26 October 2021

**Planning Referral – Advice Request
Warkworth Coal Mine – Lemington Underground Water Storage and Construction of Ultra Class Truck Workshop**

I refer to your request for advice received on 1 October 2021 regarding State Significant Development Modification SSD- 6464-Mod 2 (**MOD 2**) for the Warkworth Continuation Project for storage and sharing of water in the Lemington underground mine void and for the construction of an Ultra Class truck workshop.

FIGURE No:
1.2

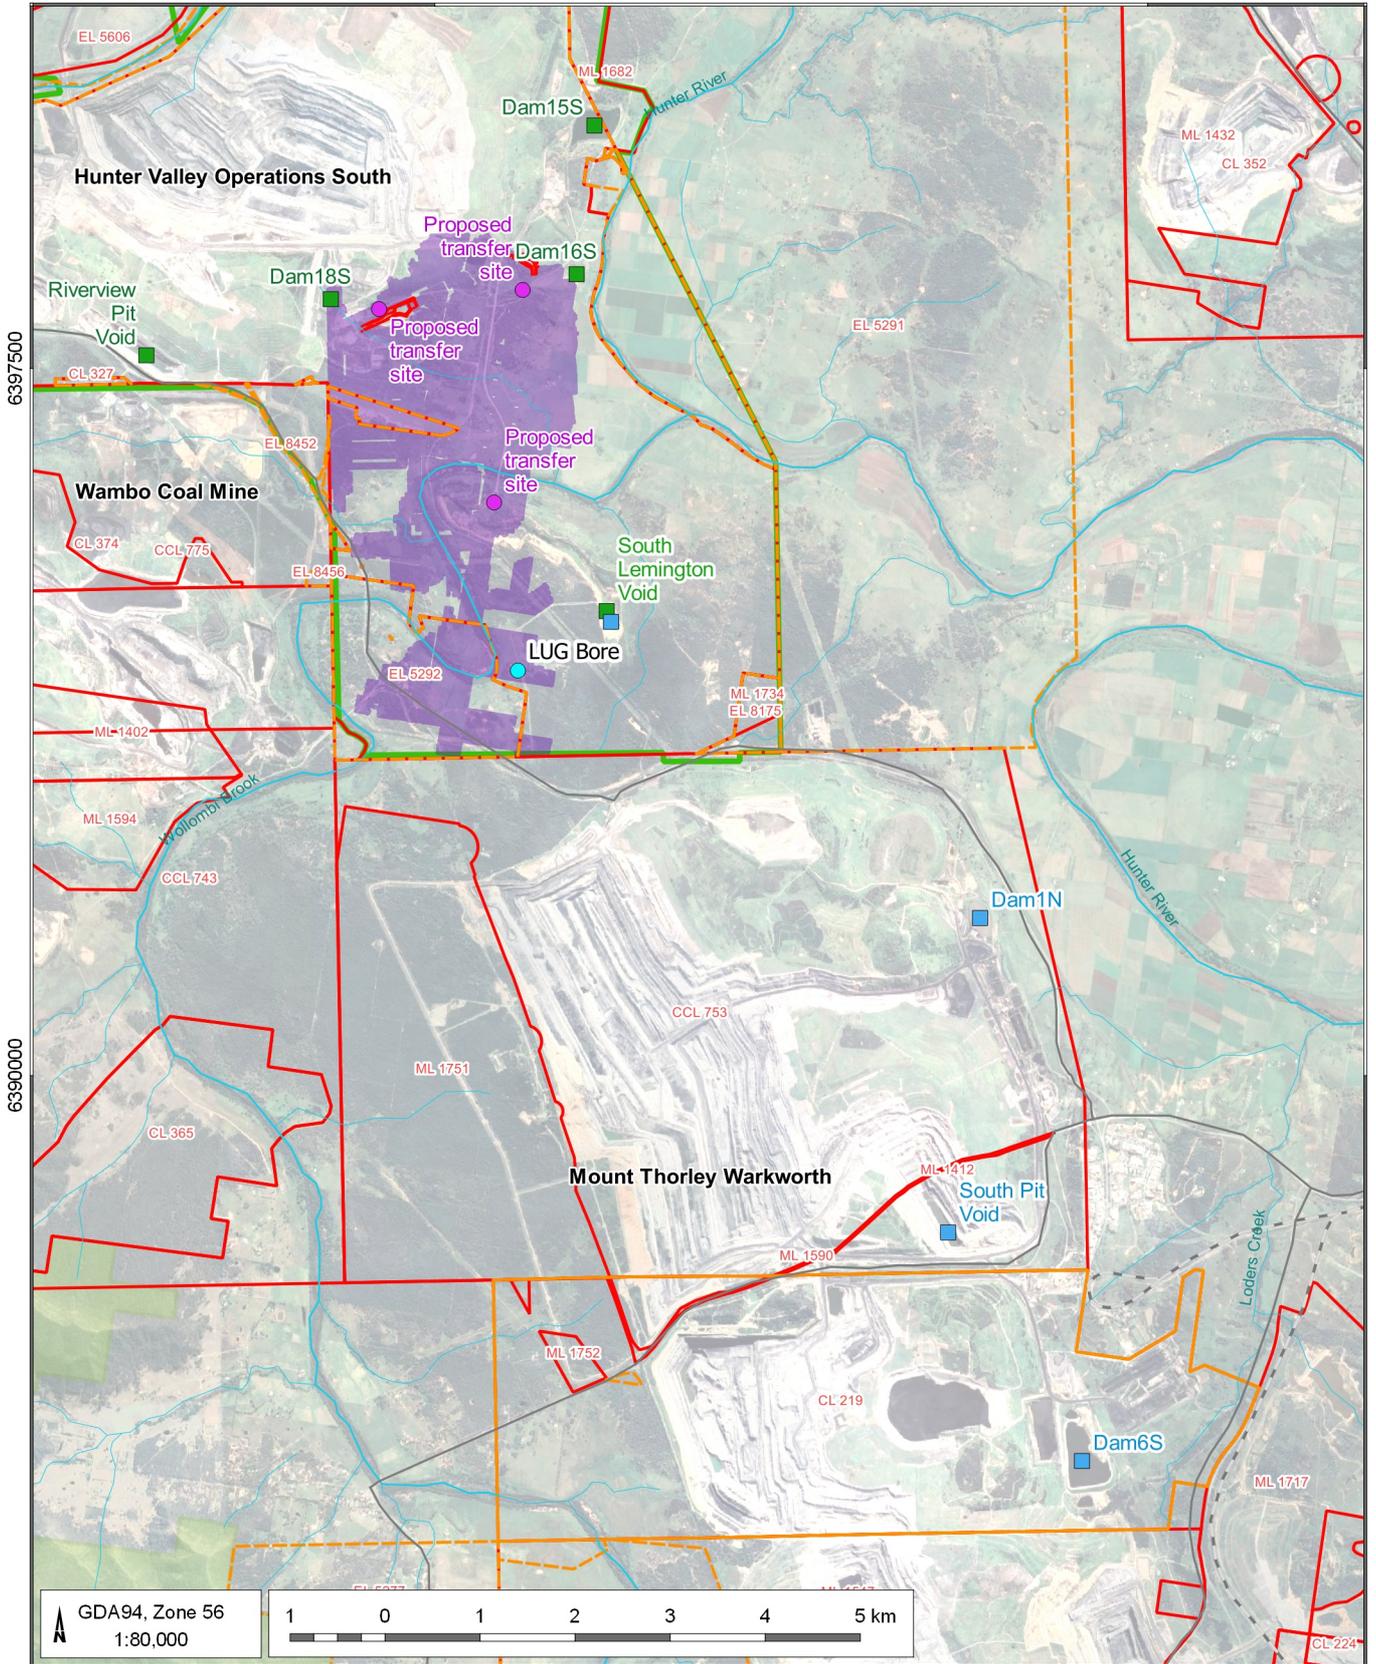
The EPA recommends that an updated Water Management plan be provided which identifies the water dams which will receive and send water to the Lemington Underground and includes any surface water discharge points, as specified on the related EPL's and delineated by the separate EPL boundaries.
